DEVELOPMENT REVIEW BOARD  
SUPPLEMENTAL SUBMITTAL

PROJECT NO. PR-2021-005390  
Application No. SI-2021-00832 and VA-2021-00217

**Re:** Hiland Plaza Comment Responses and Supplemental Information (PR-2021-005390)

This memo outlines the updates made to the site plan for the Hiland Plaza project based on the comments received and reviewed at the July 21, 2021 DRB meeting. In addition, we have provided a justification for a 6-inch deviation to the fence height provided around the patio at the corner of Central Avenue and Jackson Street, as noted on the plans due to the building code requirement to provide a railing for the grade separation between the sidewalk and the patio.

**A4 ENLARGED SITE PLAN**  
 1" = 4'-0"

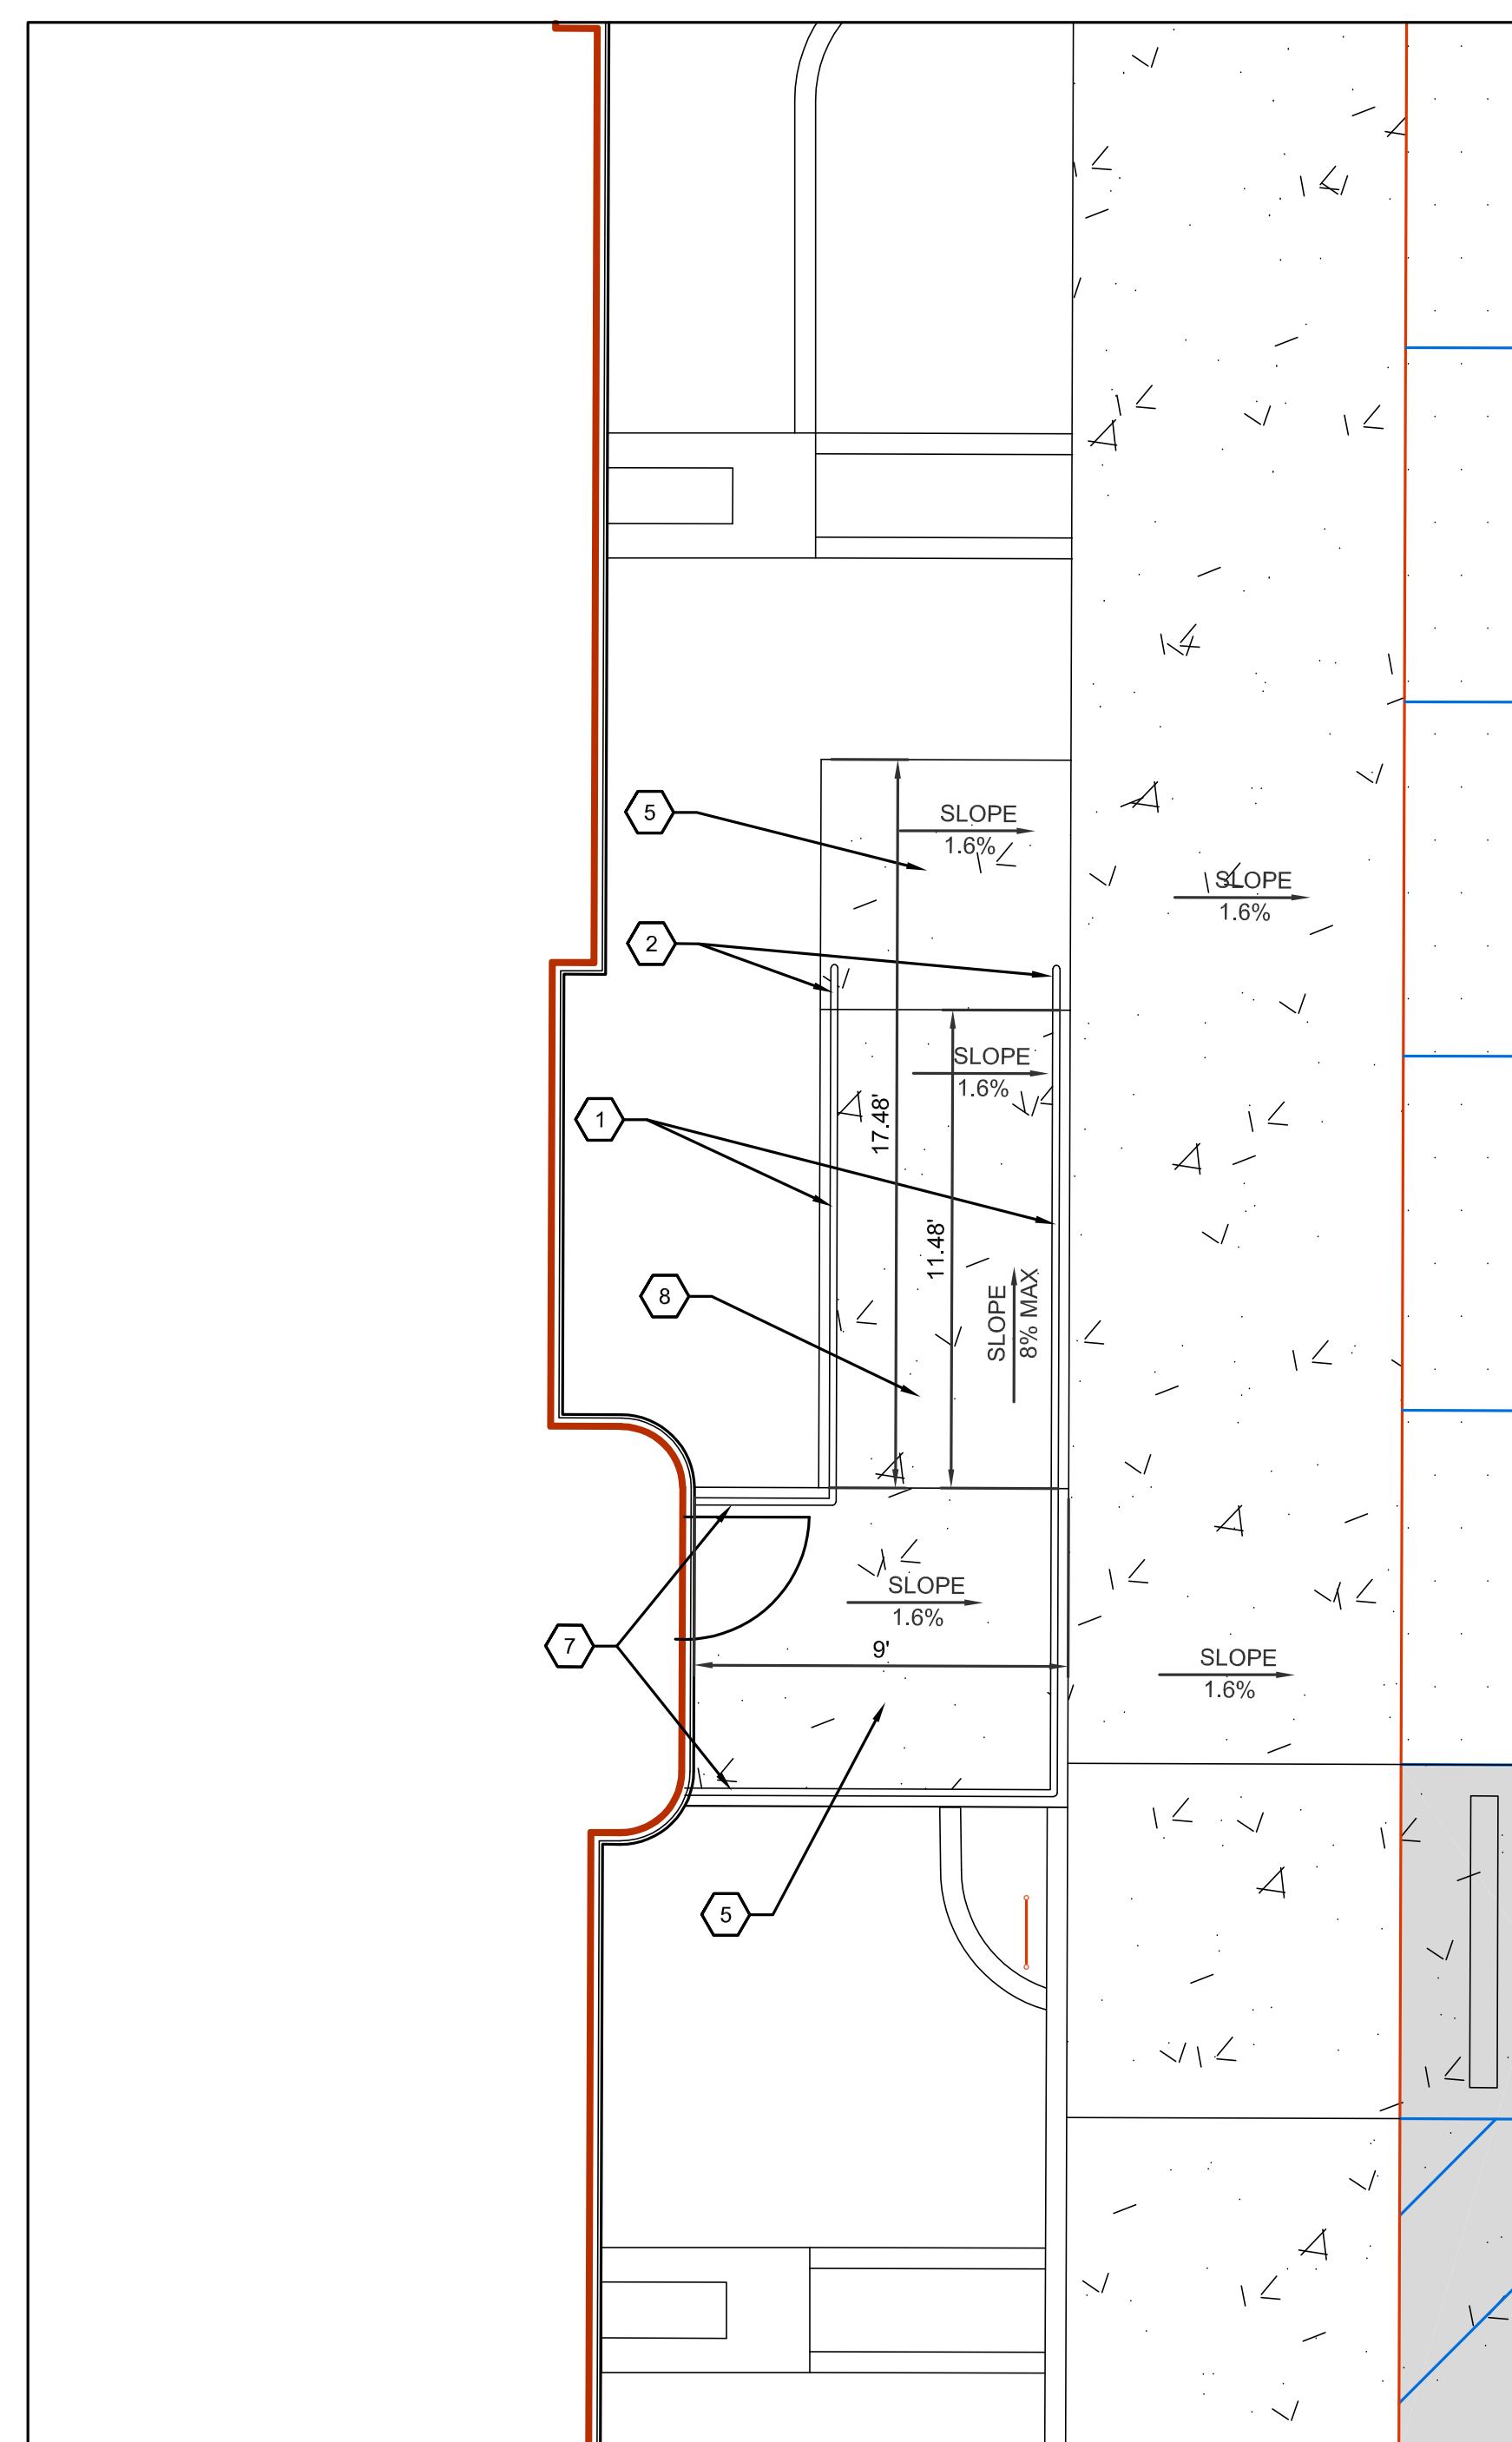
3. Specify which ramps are being used around the handicapped spaces since the turndown sidewalk detail specifies a vertical separation between the pavement and the sidewalk.

6. Provide complete detail for the ramp along the east side of the building with the handrail, showing all dimensioning. (The handrail detail provided is for the stair ramps.)

- a. Enlarged plans of ramps have been added on sheet C-102.*
4. For the corner ramp at the northwest corner, have it line up with the crosswalk, and show existing crosswalk. Drawing 2441 is more appropriate to use than Drawing 2442 in this case.

- a. Enlarged plans of ramps added on sheet C-102.*
7. Sidewalk detail shall call out a maximum 2% slope.
  - a. Note added.*
8. Clear sight is a concern with the parallel parking, particularly looking to the left when pulling out of the entrance. Further analysis of this may result in a few parallel parking spaces being eliminated. Also provide distance between centerline on Silver and parallel parking.

D3 TREE PLANTING DETAIL

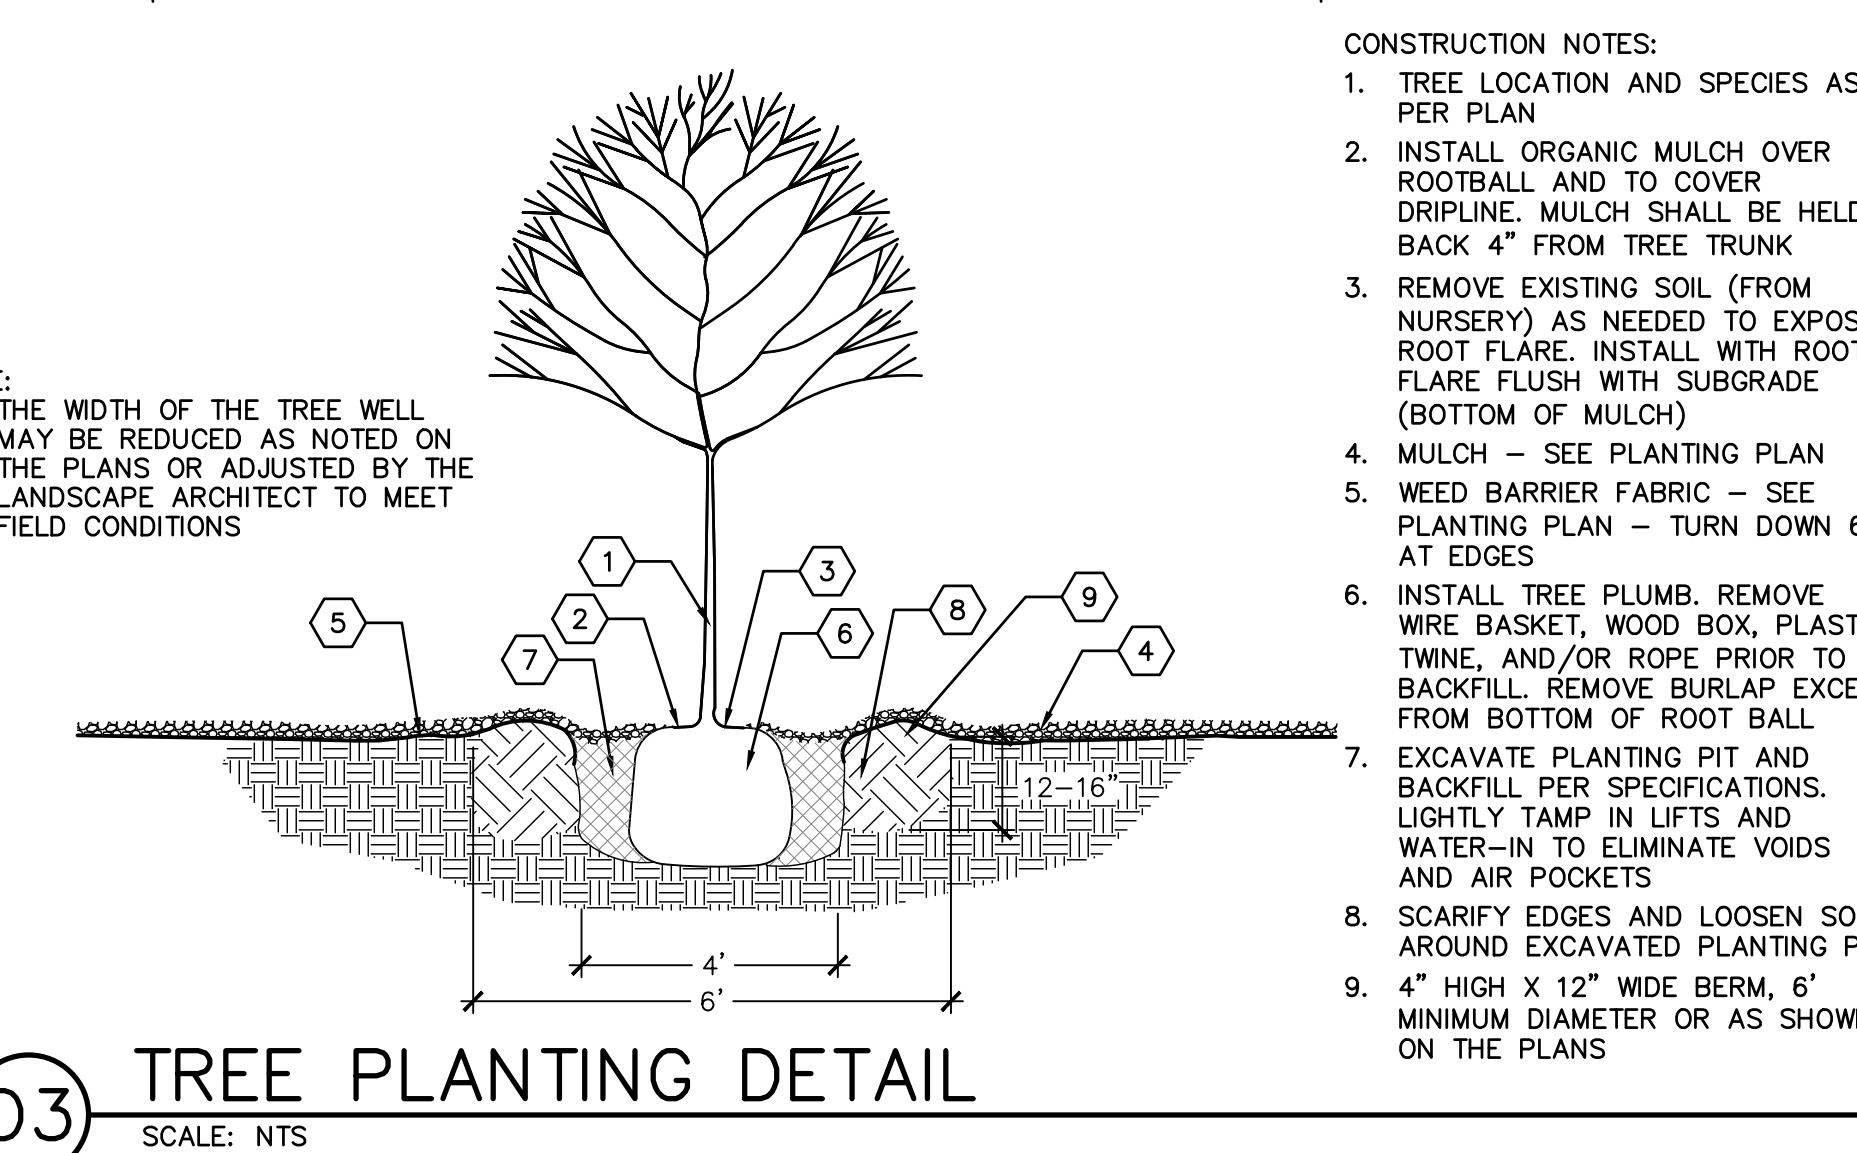
1. Please add note under tree planting detail per IDO section 5-6(C)(5)(e). Such as or similar: "Install organic wood chip mulch over rootball and to cover dripline. Generally, mulch should be held 4" back from tree trunk."
  - a. Construction Note #2 on the tree planting detail references this requirement.*

D3 WEST ELEVATION
 1/16" = 1'-0"

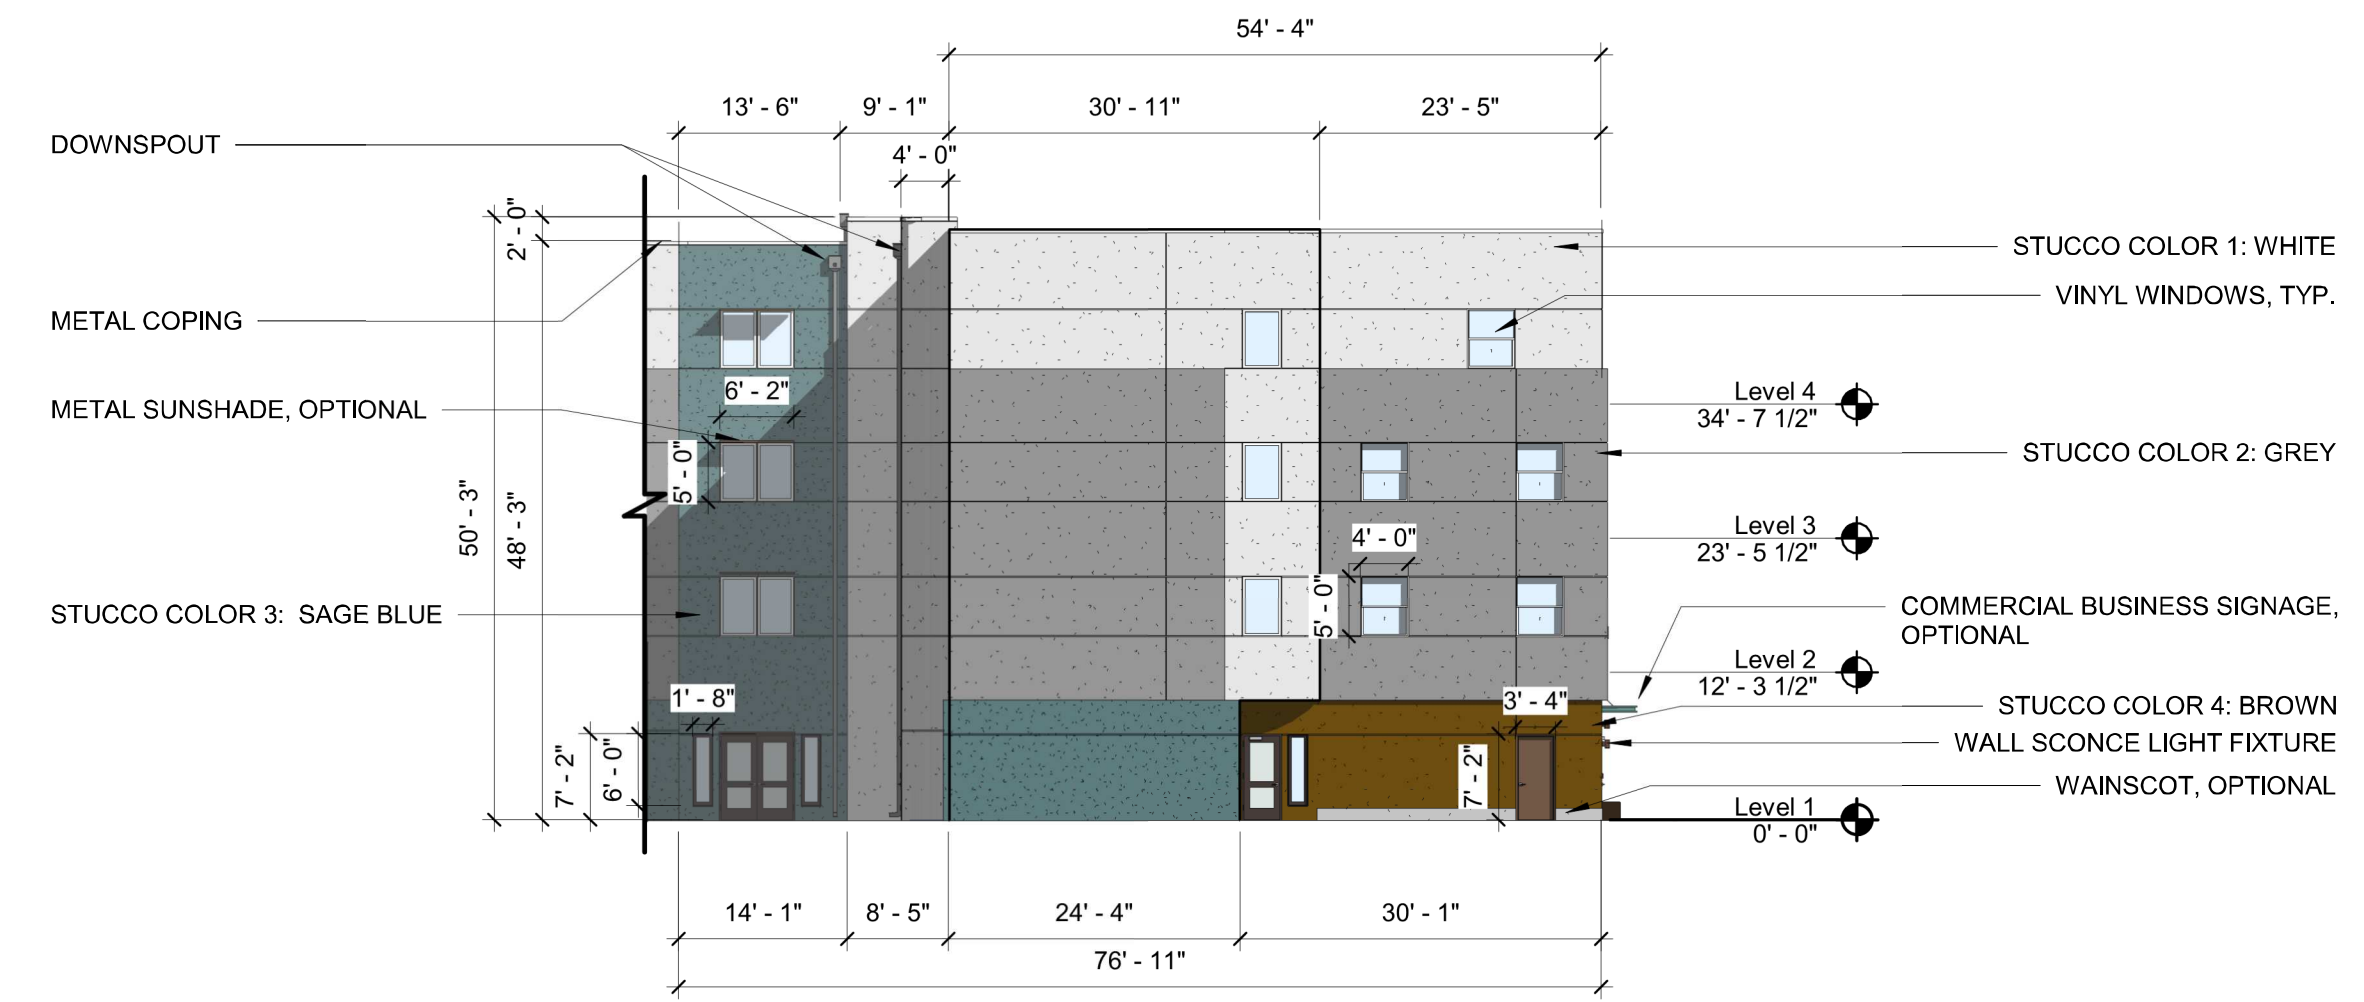
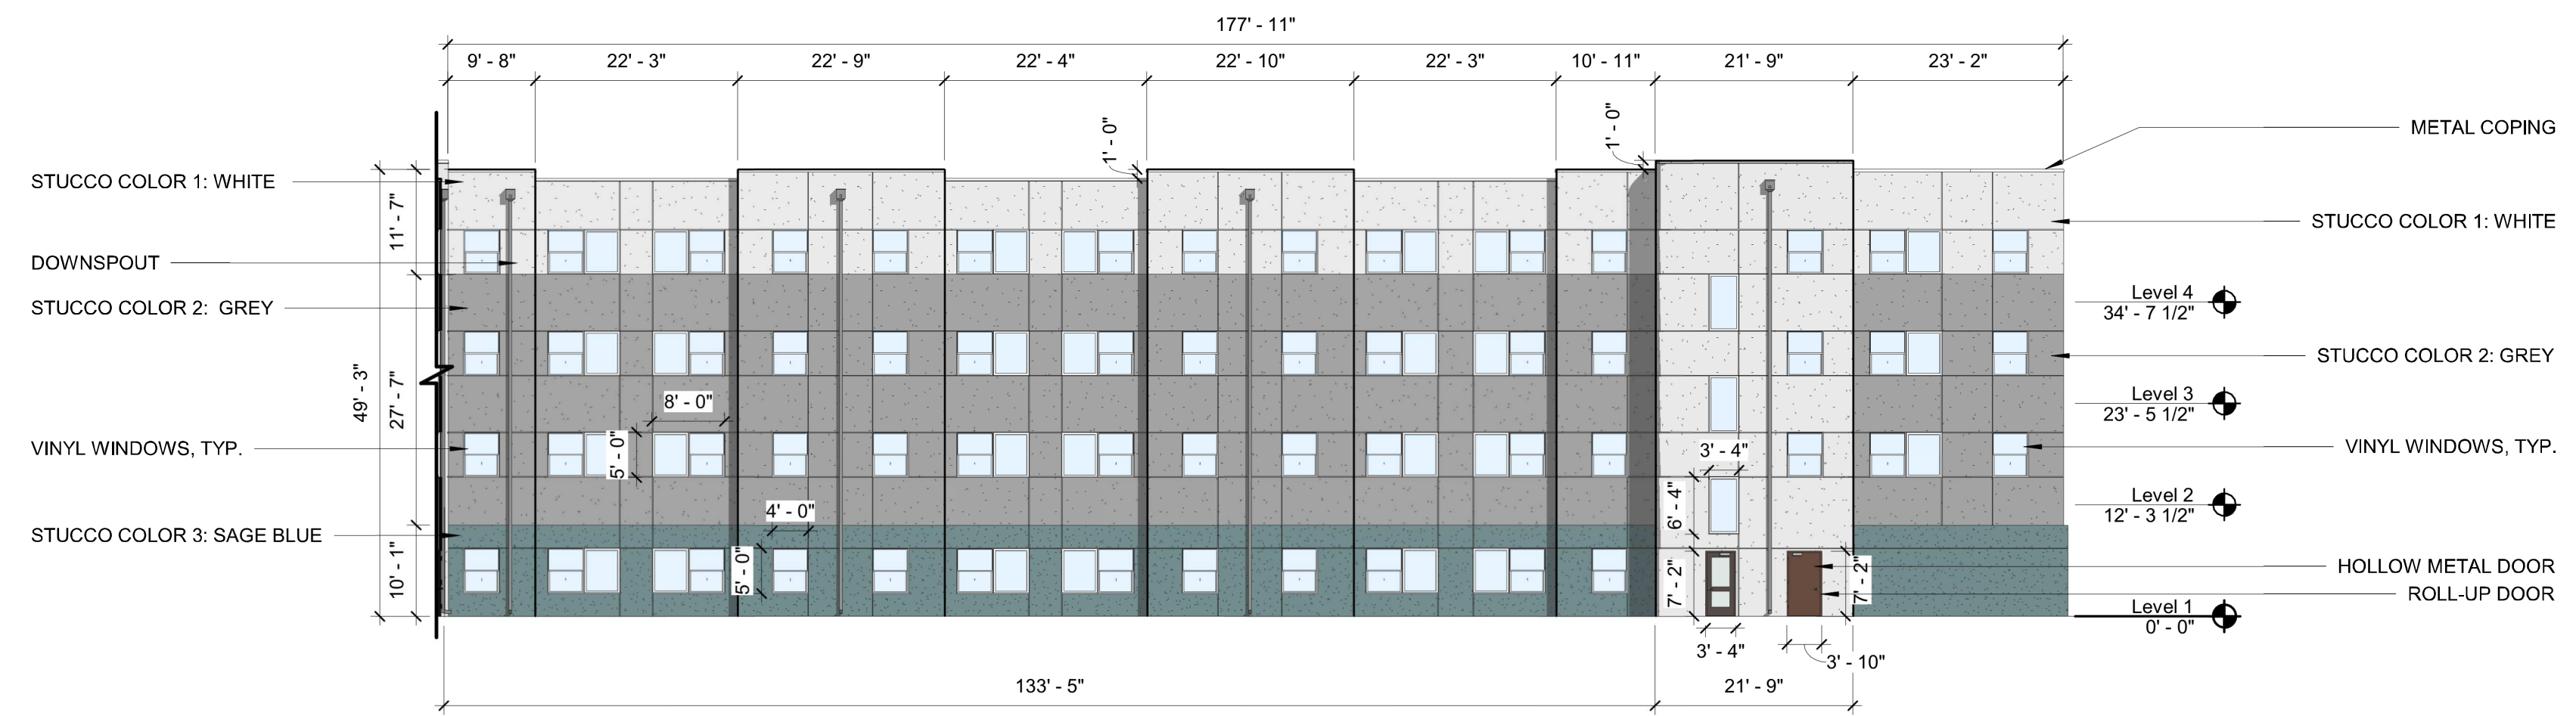
4. Provide widow detail "recessed" 5-11(D)(3) "In new multi-family residential development, windows shall be recessed not less than 2 inches and/or shall be surrounded by a window casing not less than 2 inches wide."

- a. *Understood. Planting details were updated based on Parks and Recreation comment.*
3. Please address how the façade meets these standards
4. 5-11(D)(3) Windows In new multi-family residential development, windows shall be recessed not less than 2 inches and/or shall be surrounded by a window casing not less than 2 inches wide.

- a. *Note referencing this requirement has been added to the building elevation sheet.*
5. 5-11(D)(2)(b) In UC-MS-PT areas, each floor of every façade that faces a public street shall contain a minimum of 20 percent of the façade in transparent windows and/or doors.

The west elevation with a long building wing should account for strong solar radiation effects on this western facade. Consider using heat mitigation features for windows facing west (exterior or interior shades, recesses, specialized glazing, etc.). AND

- a. *A note has been added to the elevations to address compliance with this standard.*

- a. *Note referencing this requirement has been added to the building elevation sheet. It should be noted that this requirement is superseded by the Nob Hill/Highland CPO requirements. We have also added notes regarding the variances to those requirements heard by the Zoning Hearing Examiner.*

- a. *These items were discussed at the DRB meeting on July 21, 2021 and the architect explained the types of windows glazing and insulation provided on this façade.*
7. A platting action consolidating the 22 lots comprising the site must be approved prior to approval of the Site Plan.
  - a. *The lot consolidation plat was approved by the DRB at the July 28, 2021 meeting and is pending final signature to align with this site plan request and infrastructure list.*
